APPLICATION NO. 03DRB-01879	PROJECT NO. 1003091
PROJECT NAME COLES INDUSTRIAL SUBD.	
EPC APPLICATION NO.	
APPLICANT / AGENT SURVELS SOUTHWEST	PHONE NO. 998-0303
ZONE ATLAS PAGE H-16-7	
(SDP for SUB), (SDP for BP), (FINAL PLATS) (MASTER DEV PLAN) (IR) (AA)	
(R) ONE STOP COMMENT FORM LOG

PLAT OF
 TRACTS B-1-A & B-1-B
 COLE'S INDUSTRIAL SUBDIVISION, UNIT 1
 SITUATE WITHIN SECTION 10,
 T. 10 N., R. 3 E., N.M.P.M.
 CITY OF ALBUQUERQUE
 BERNALILLO COUNTY, NEW MEXICO
 OCTOBER, 2003

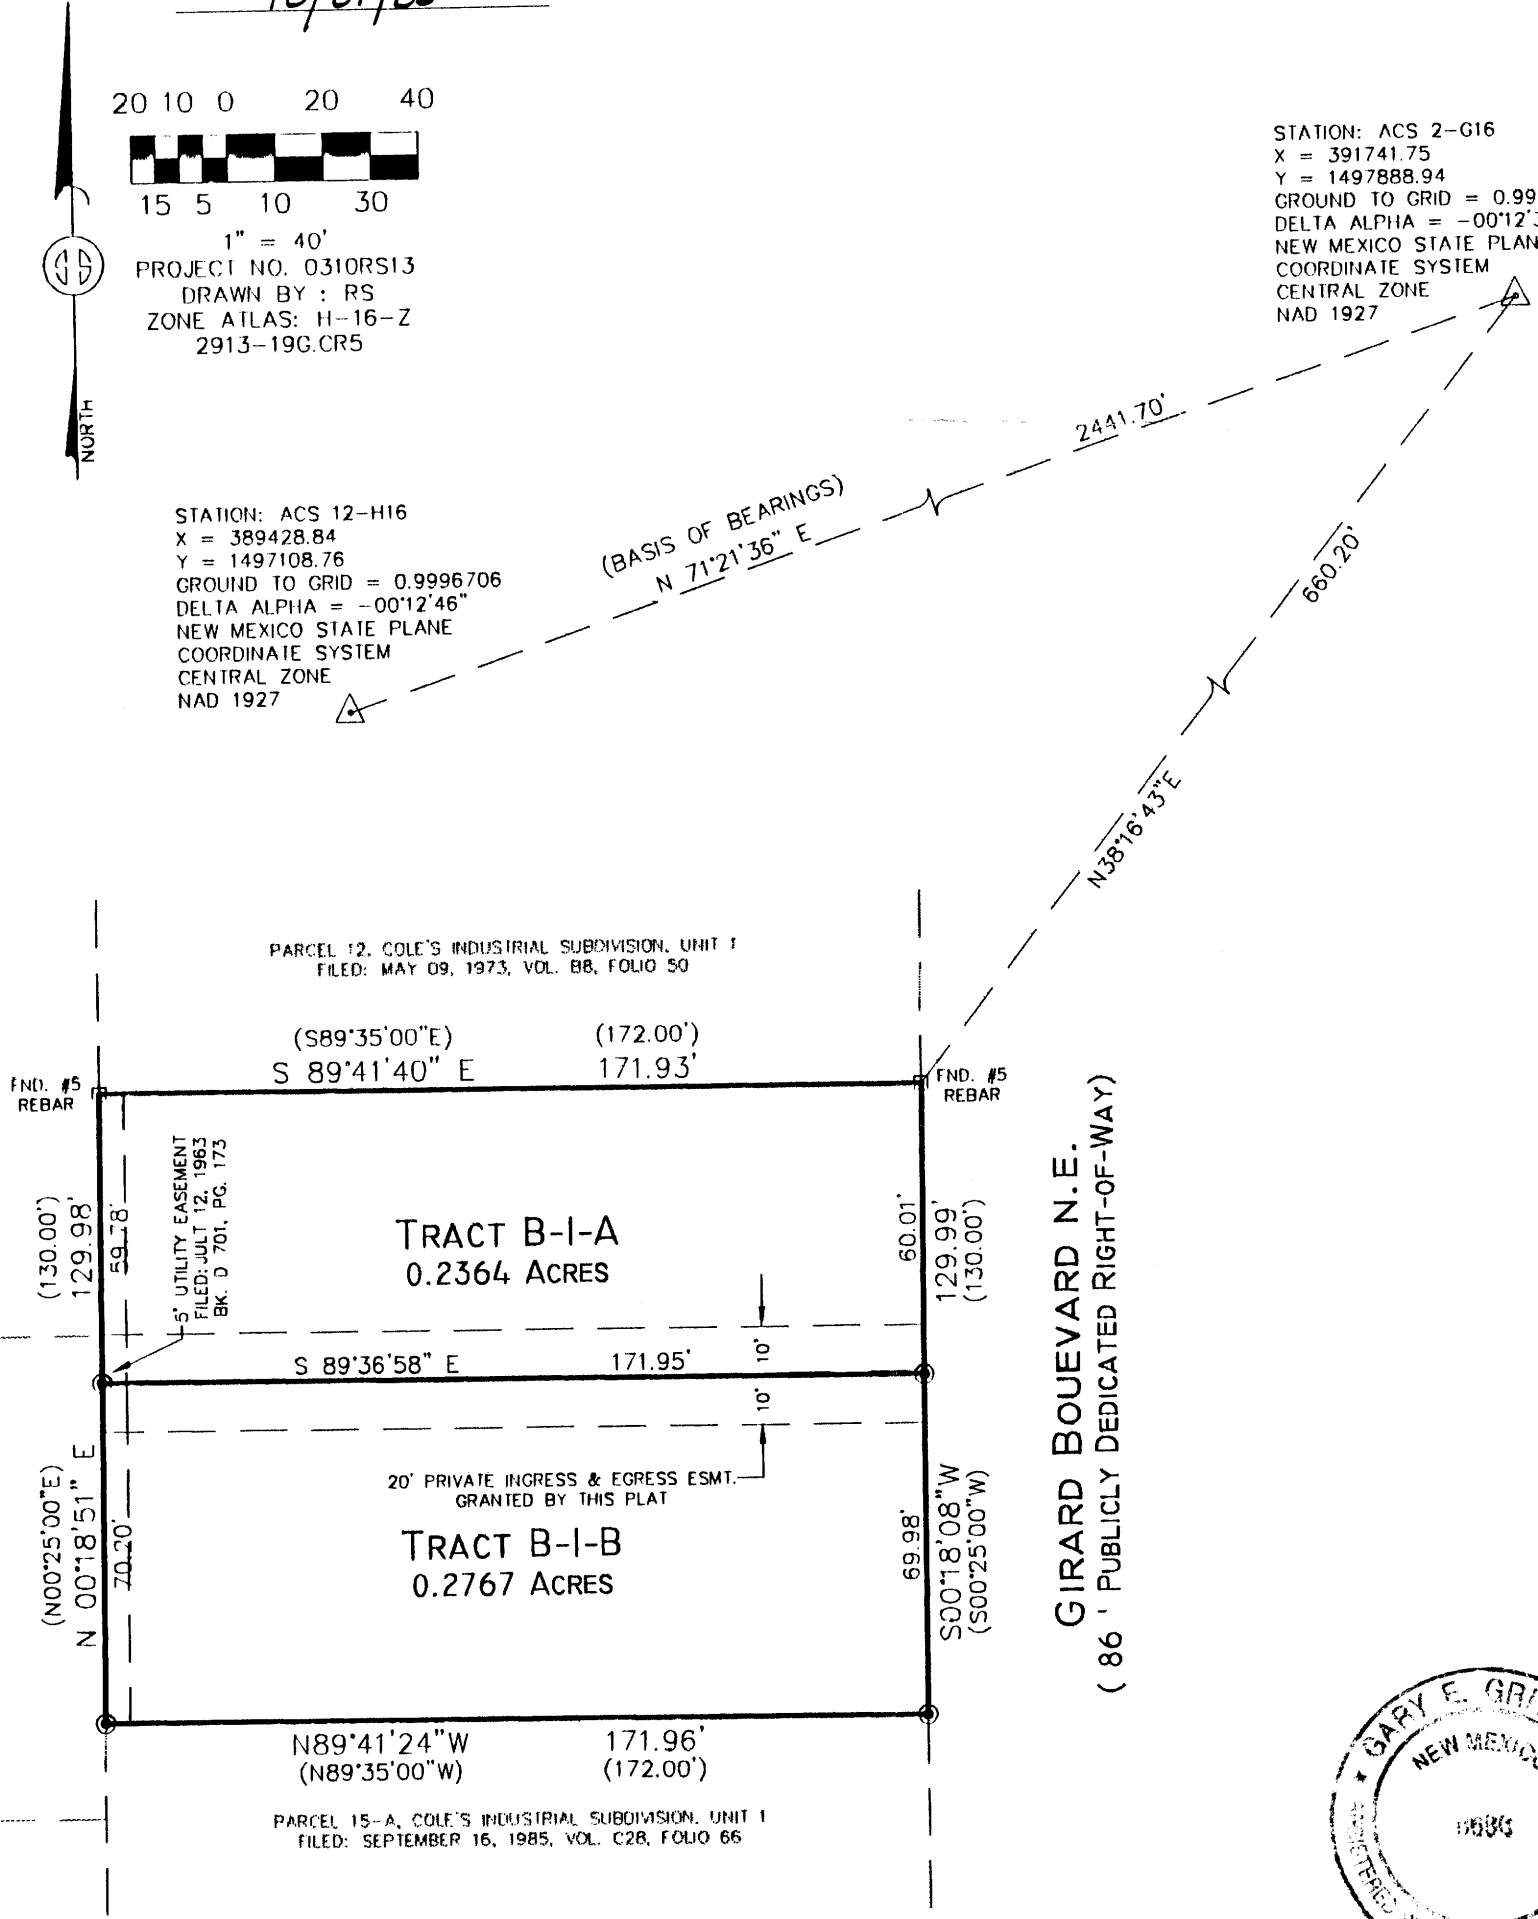
UTILITY DEV (505) 924-3989		
PLANS DISAPPROVED RAI	DATE 11/5/03 / 11/6/03	DATE
PLANS APPROVED DSM	DATE 11/07/03	DATE
COMMENTS:		
What are addresses of Site? I find only one water/sewer account for lot B-1. Must have separate account and service lines for each new lot.
